Liz Garlinge
Strategic Customer Projects
Director
National Highways
The Cube
199 Wharfside Street
Birmingham
B1 1RN

27 October 2023

GATWICK NORTHERN RUNWAY PROJECT - RELEVANT REPRESENTATION

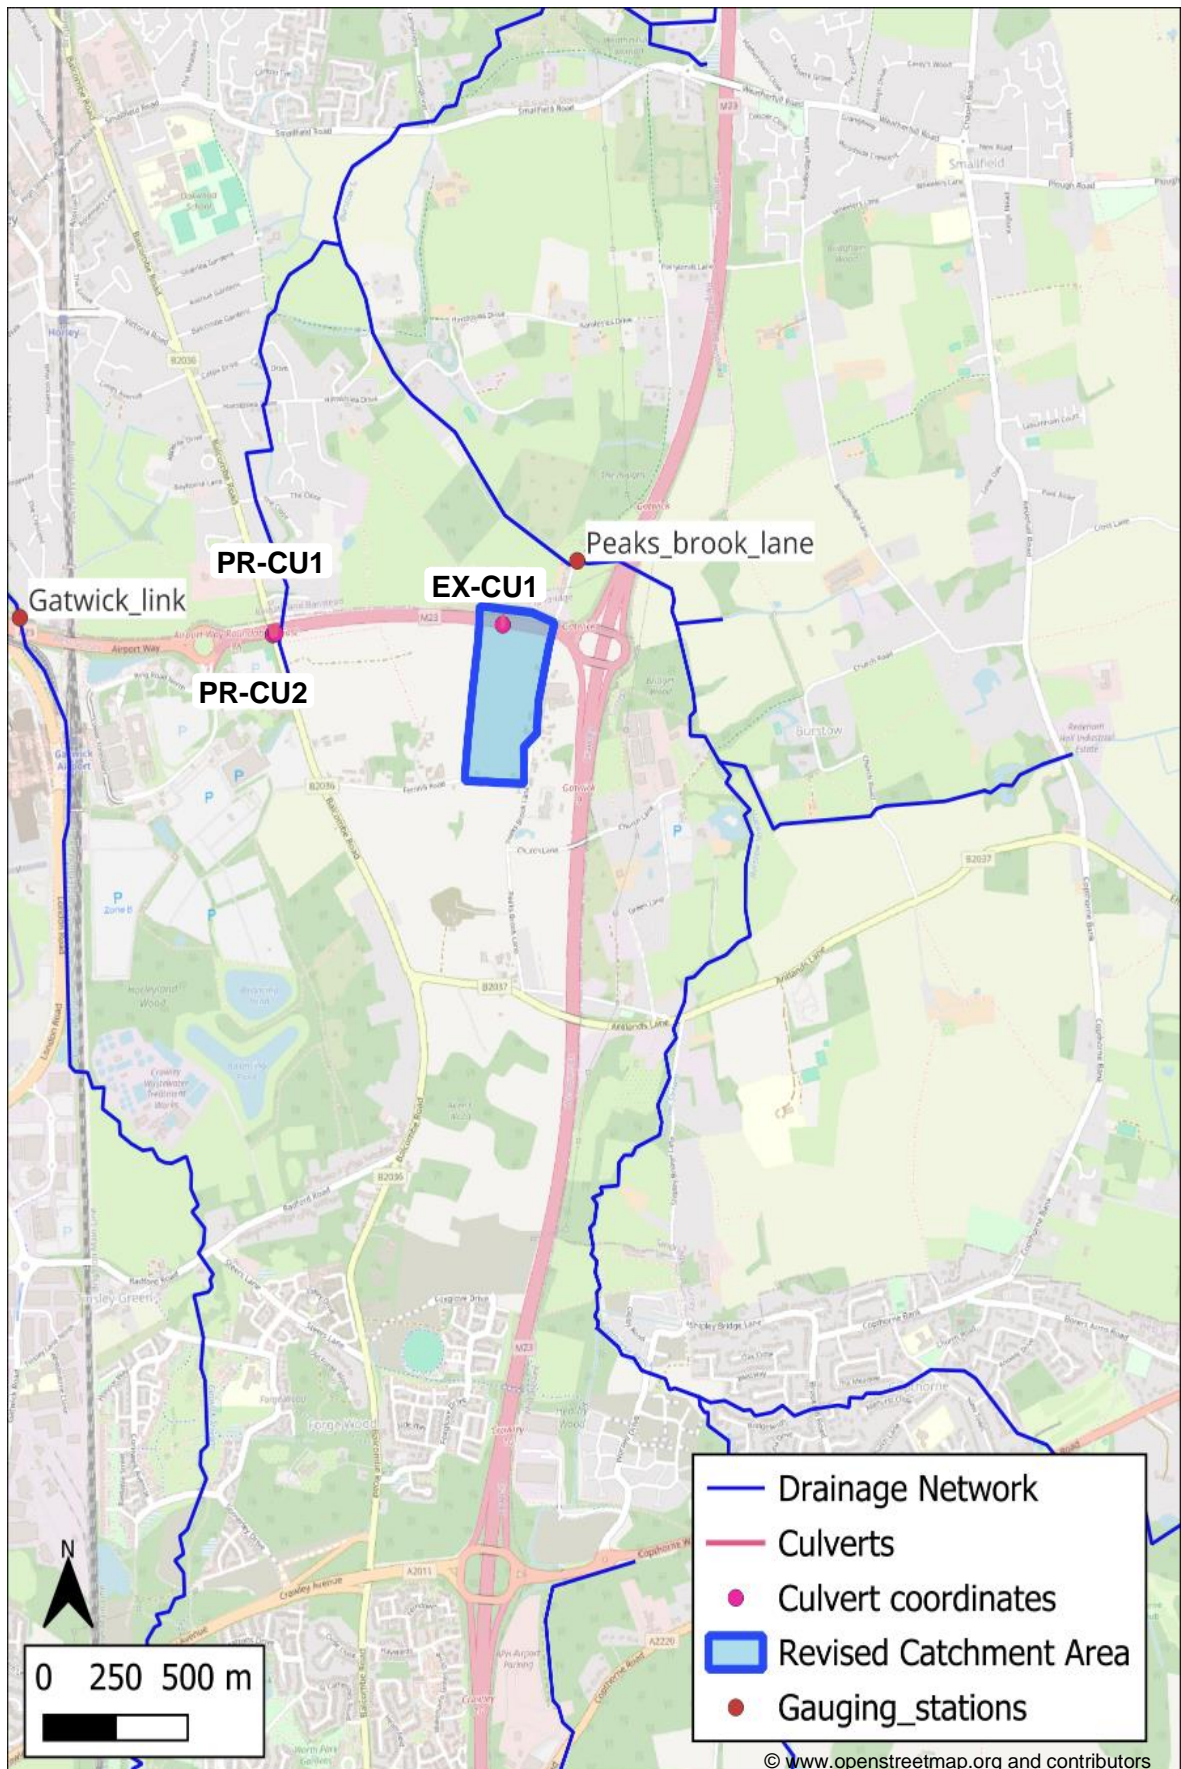
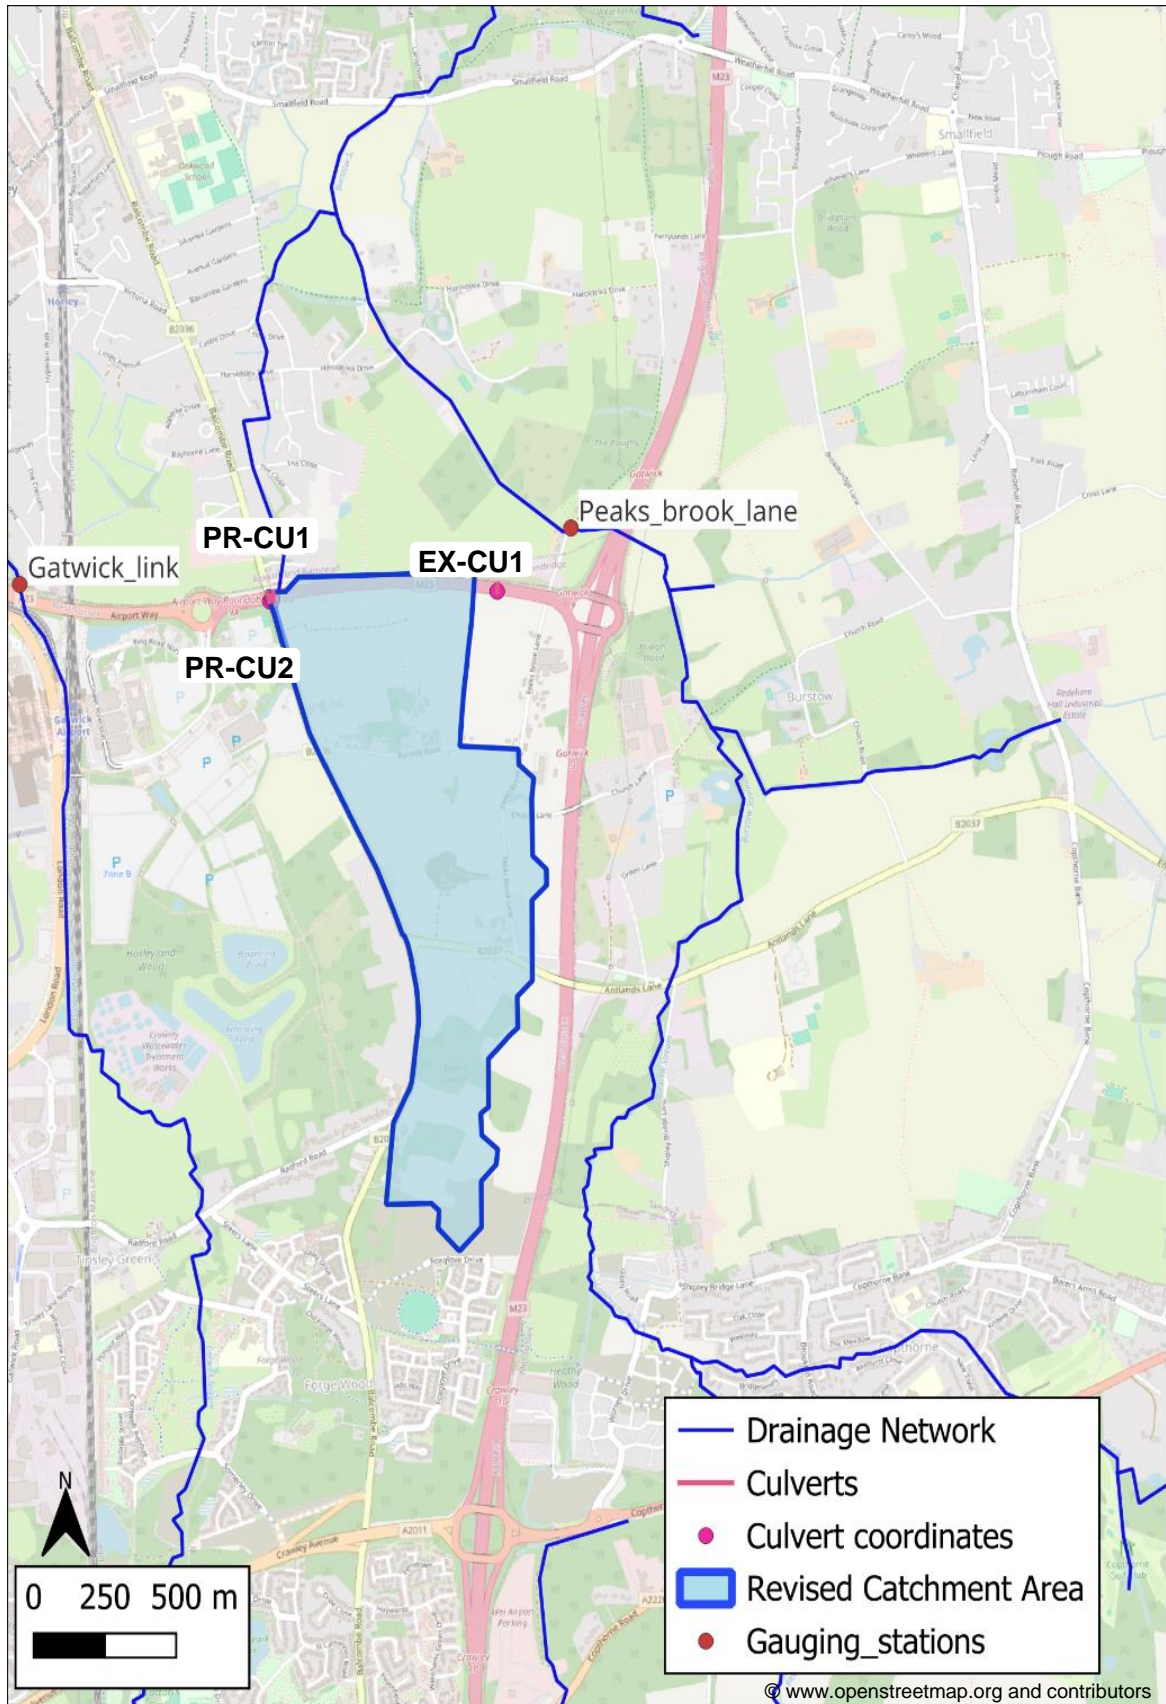
<p>Environmental Statement Appendix 11.9.6: Flood Risk Assessment (TR020005/APP/147)</p> <p>Annex 2 Figure 10.1.8 and 10.1.9</p>	<p>In Annex 2 Figure 10.1.8 and 10.1.9 provided by Applicant, the figures depict two culverts over watercourses (EX-CU1 and EX-CU2), however no details have been provided by the Applicant in regard to their sizing or whether they have been assessed.</p> <p>It is not clear how these existing culverts have been assessed from a flood risk assessment perspective.</p>	<p>The Applicant is to confirm sizing and provide details of any assessment of the impact on flood risk and freeboard for EX-CU1 and EX-CU2 on Gatwick Spur road.</p>	<p>Medium</p>
